From: Matthew Chadwick
Sent: 20 January 2020 17:01
To: DC.Consults
Subject: FW: 19/02796/F

From: Judith Ward <Judith.Ward@Cherwell-DC.gov.uk>
Sent: 20 January 2020 12:02
To: Matthew Chadwick <Matthew.Chadwick@Cherwell-DC.gov.uk>
Subject: 19/02796/F

Judith Ward
Landscape Planning Officer
Cherwell District & South Northants Councils

Drawing Title
Tree Works Plan with mitigation planting

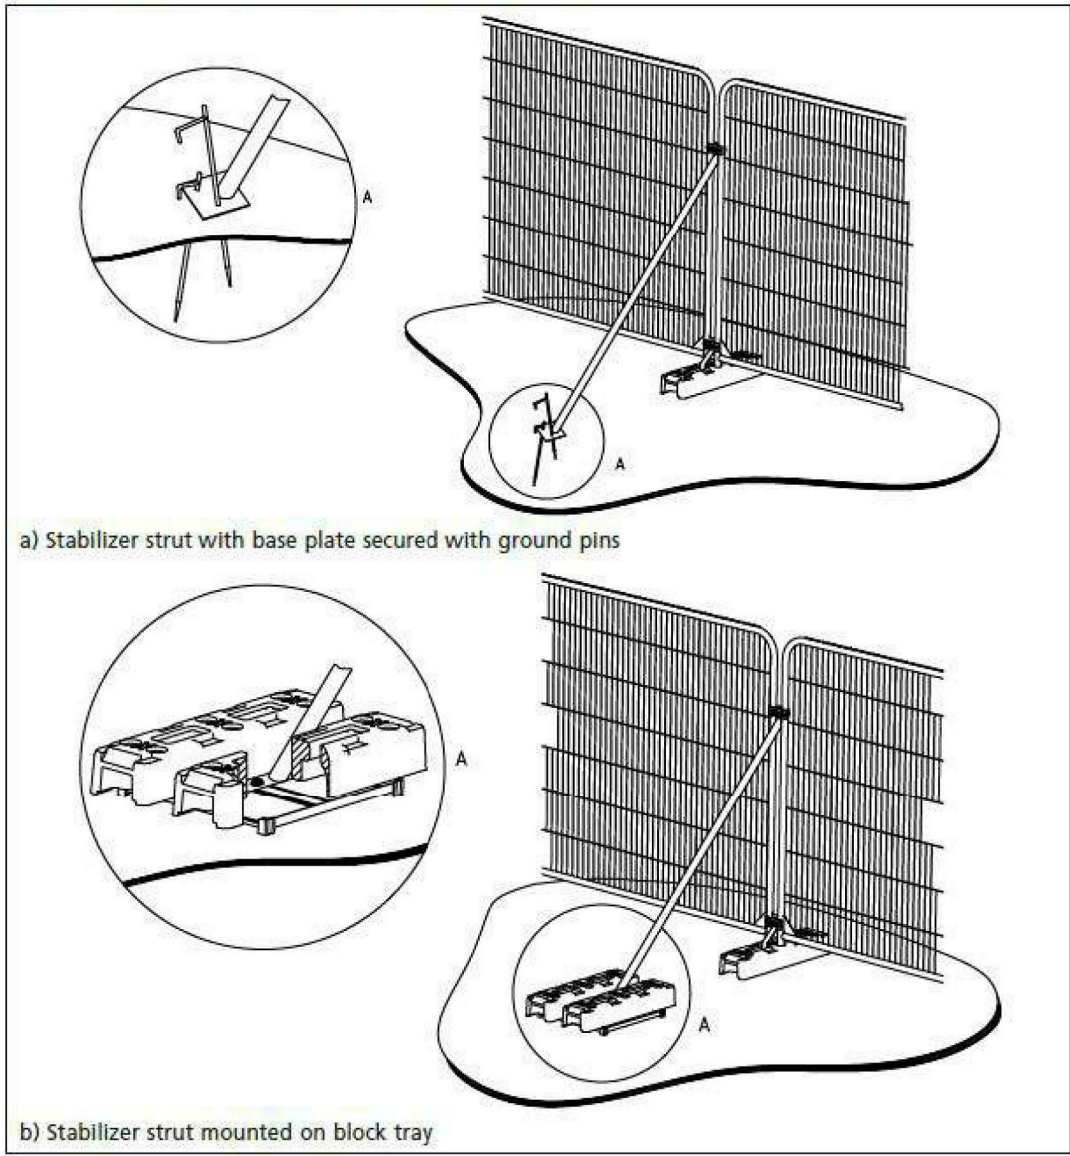
There is also a lack of detail for the removal of part of the hedge-line along Milton Road to allow access to the site. And no detail about retention of any hedgerows around the site boundaries.
